3 Pleasant Ave Amendment App & Fast Track

From: John Shields <jshields1@maine.rr.com>
To: "Laurie Leader" <lr@portlandmaine.gov>
Cc: "Bob Gaudreau" <Bob@hardypond.com>
Date: Mon, 23 May 2016 12:31:01 -0400
Subject: 3 Pleasant Ave - Revision No 4

EL SELF CONTAINED EMERGENCY LIGHT W/2 HEADS DUAL-LITE (LED) MODEL LZ651-03L, 65 WATTS FOR 90 MINUTES, COLOR BY ARCHITECT.

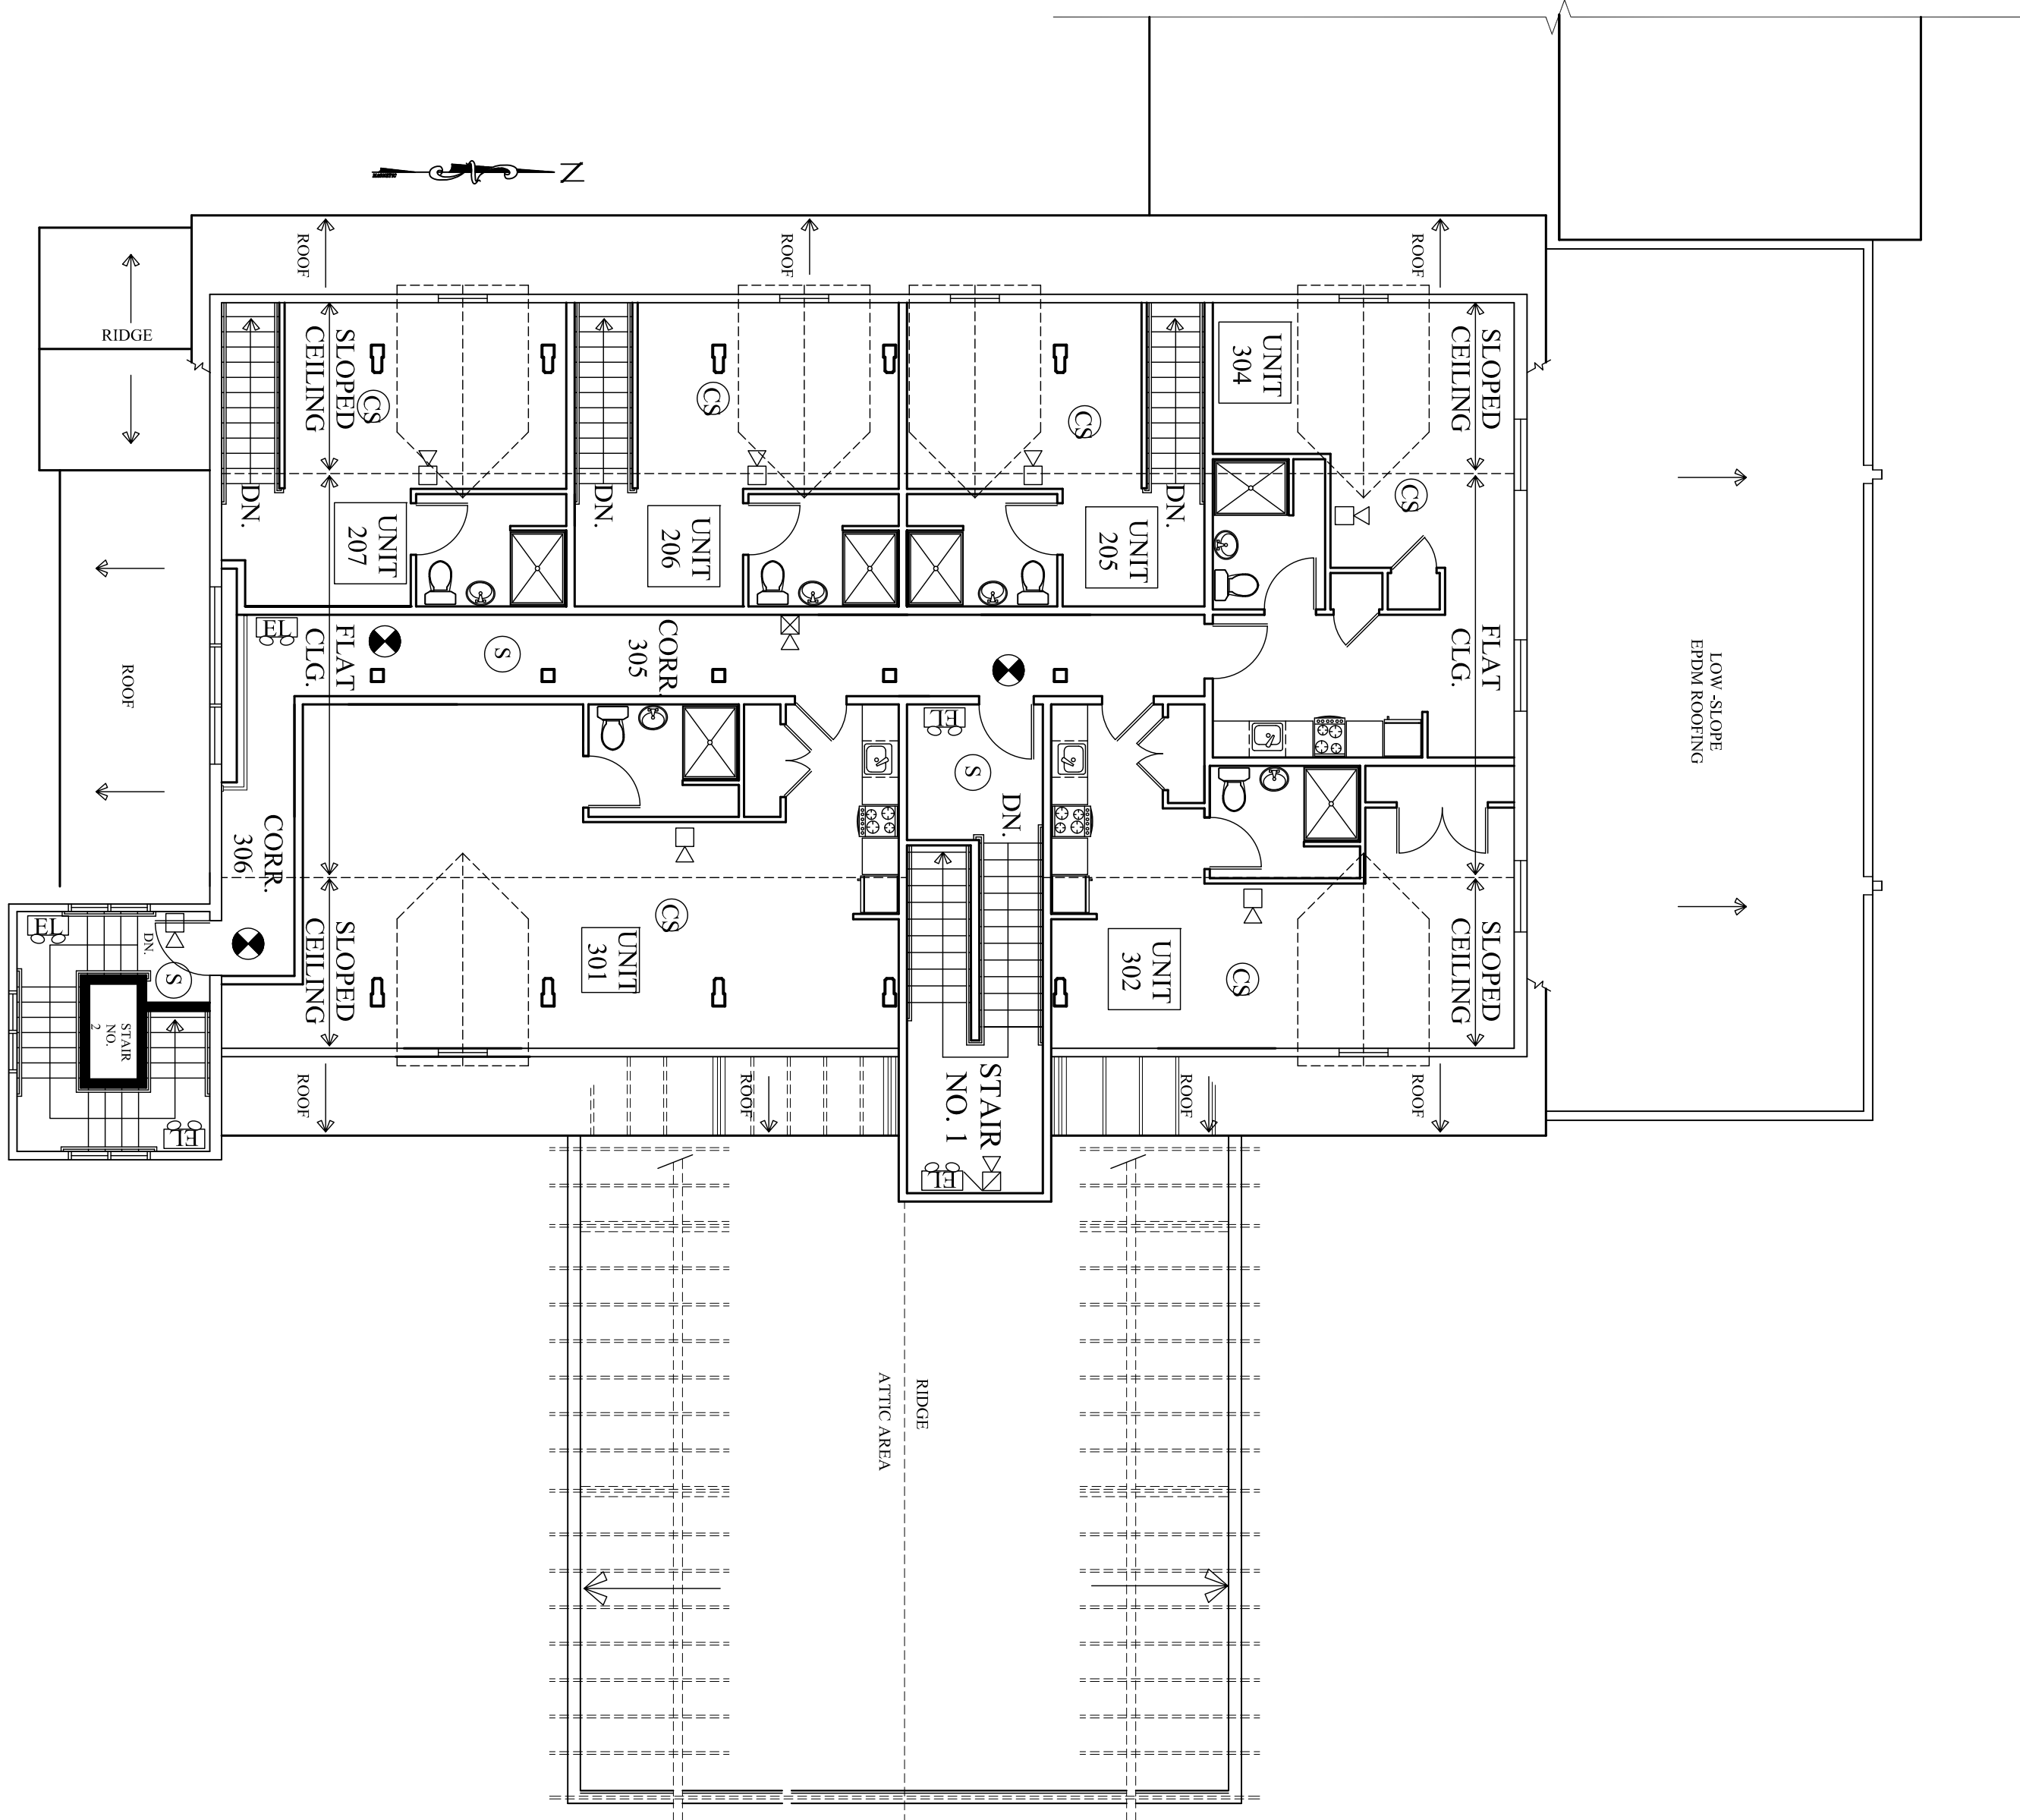
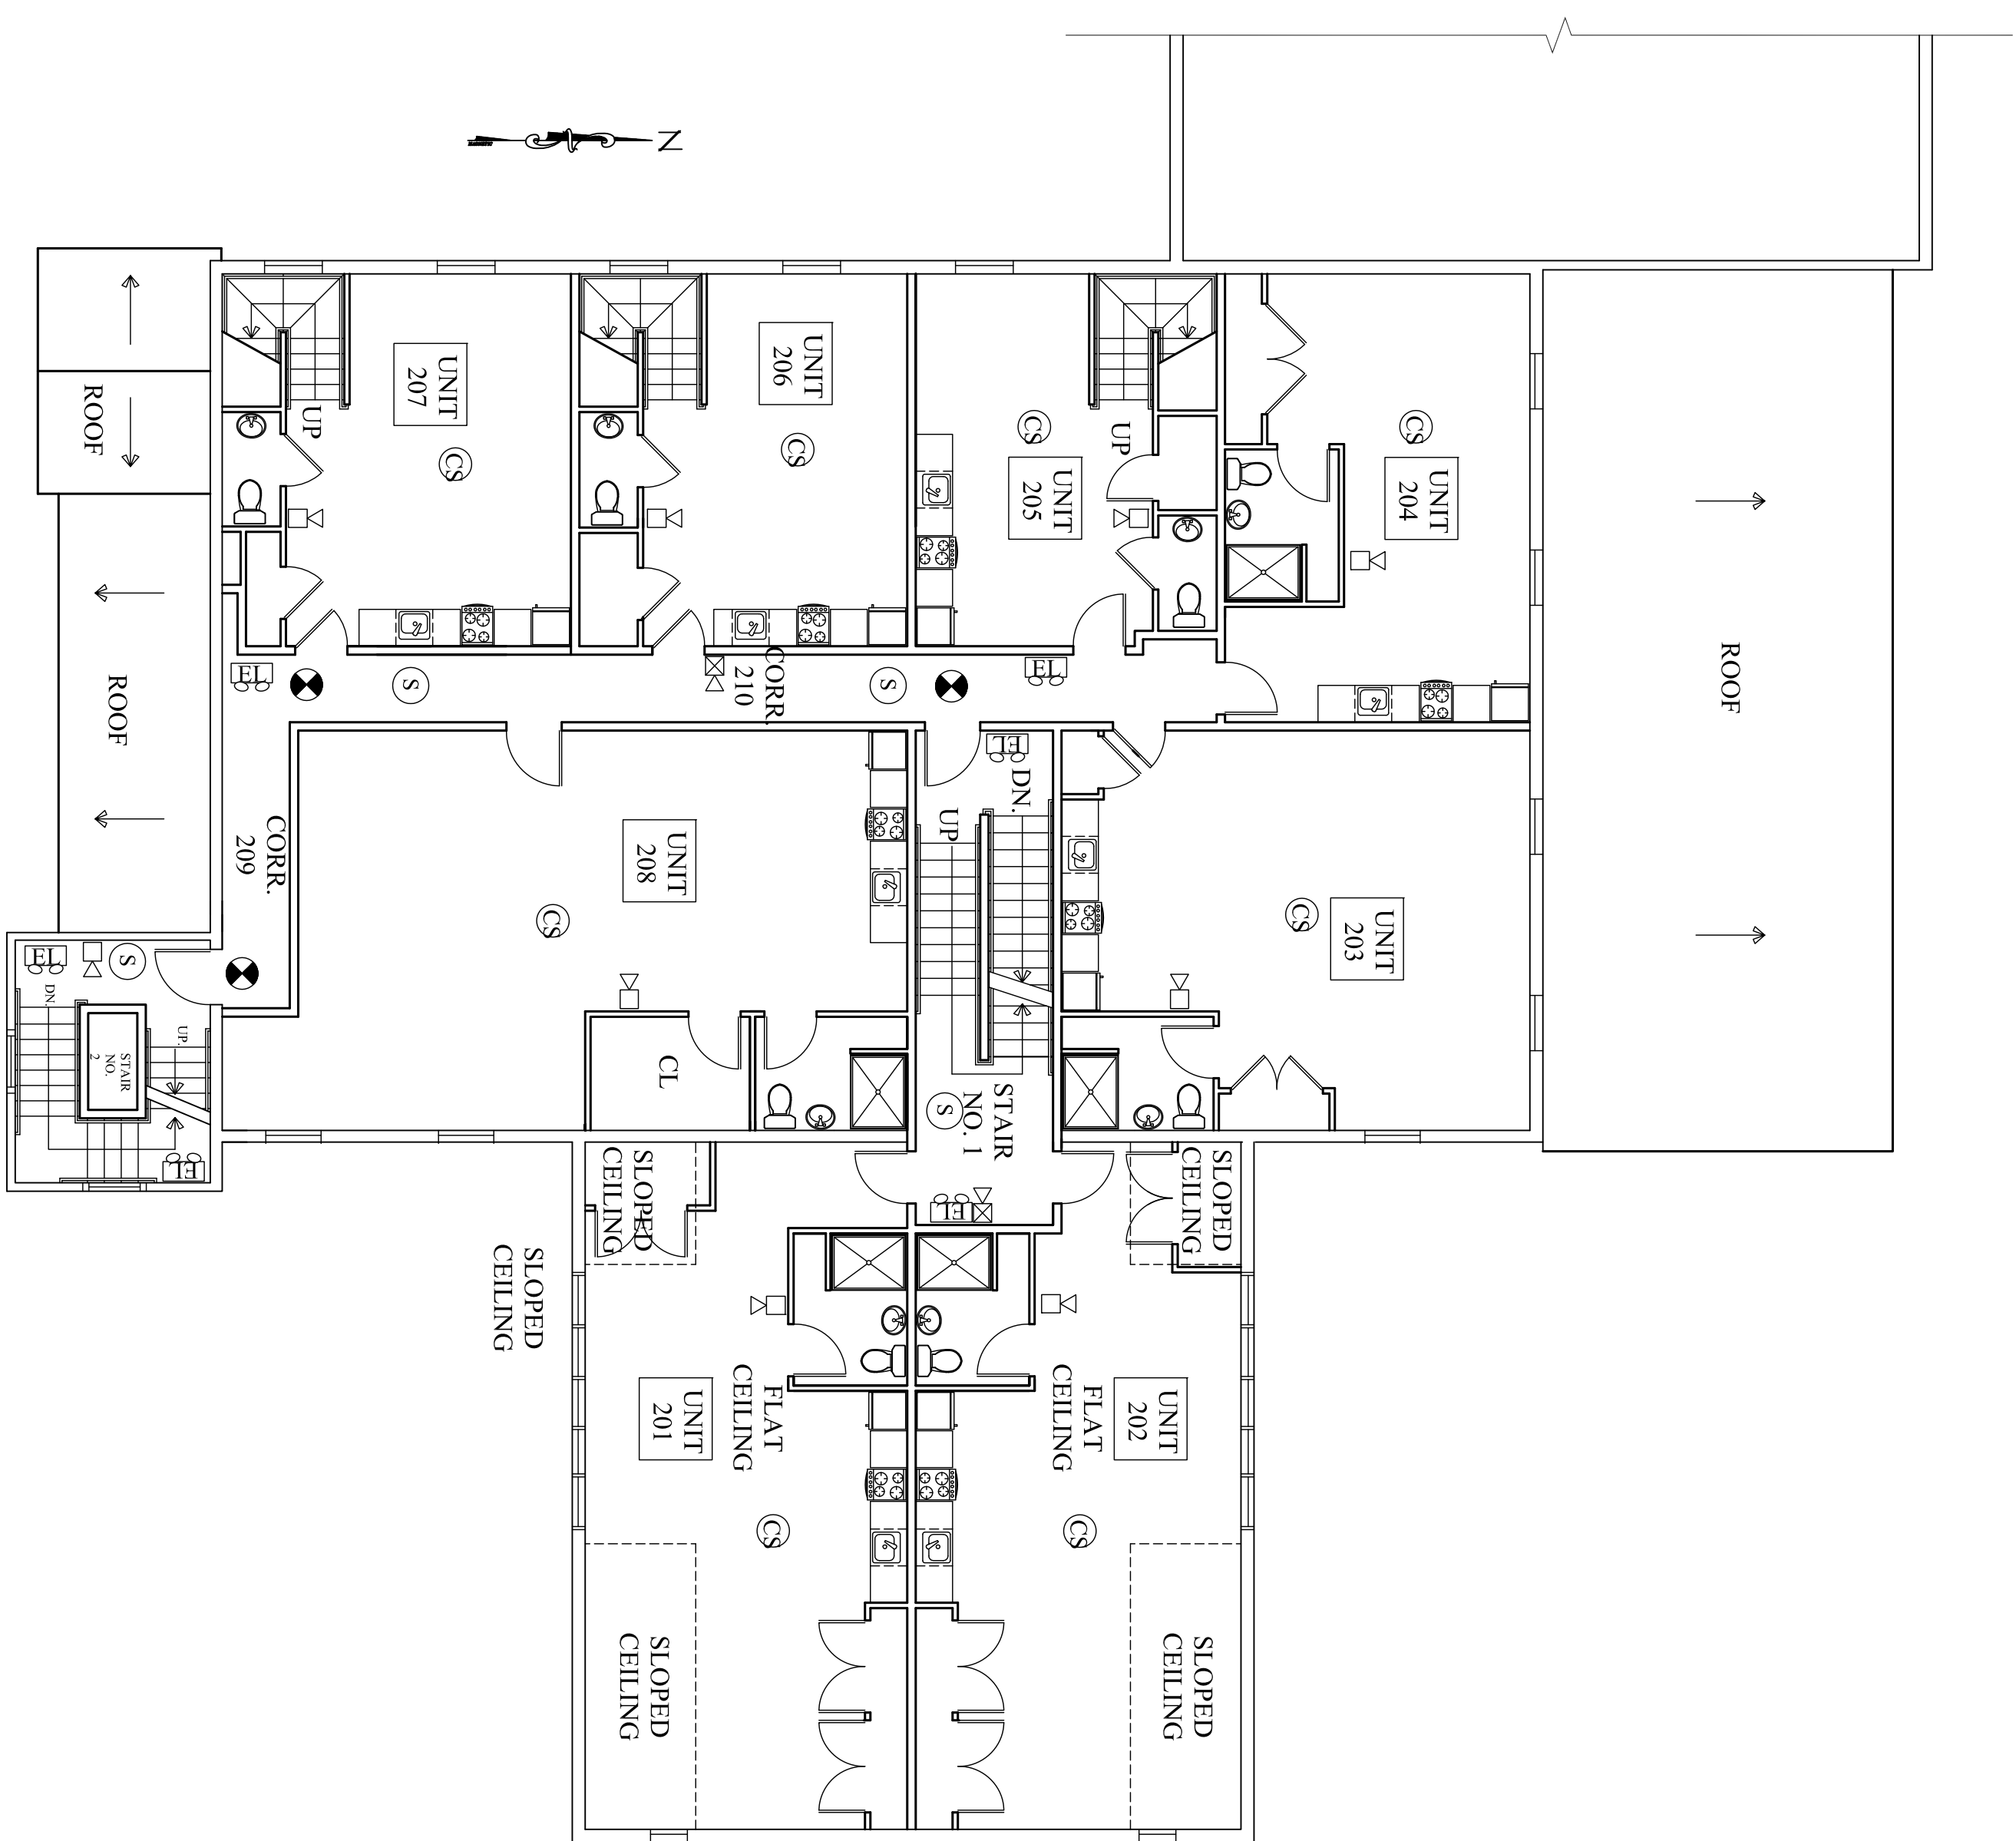
10. Drawing A-16 Fire Alarm & Smoke/CO Detector Plans: Basement Plan revised to show Mechanical Room 008 location.
11. Drawing A-17 Life Safety Plans: Basement Plan revised to show Mechanical Room 008 location.
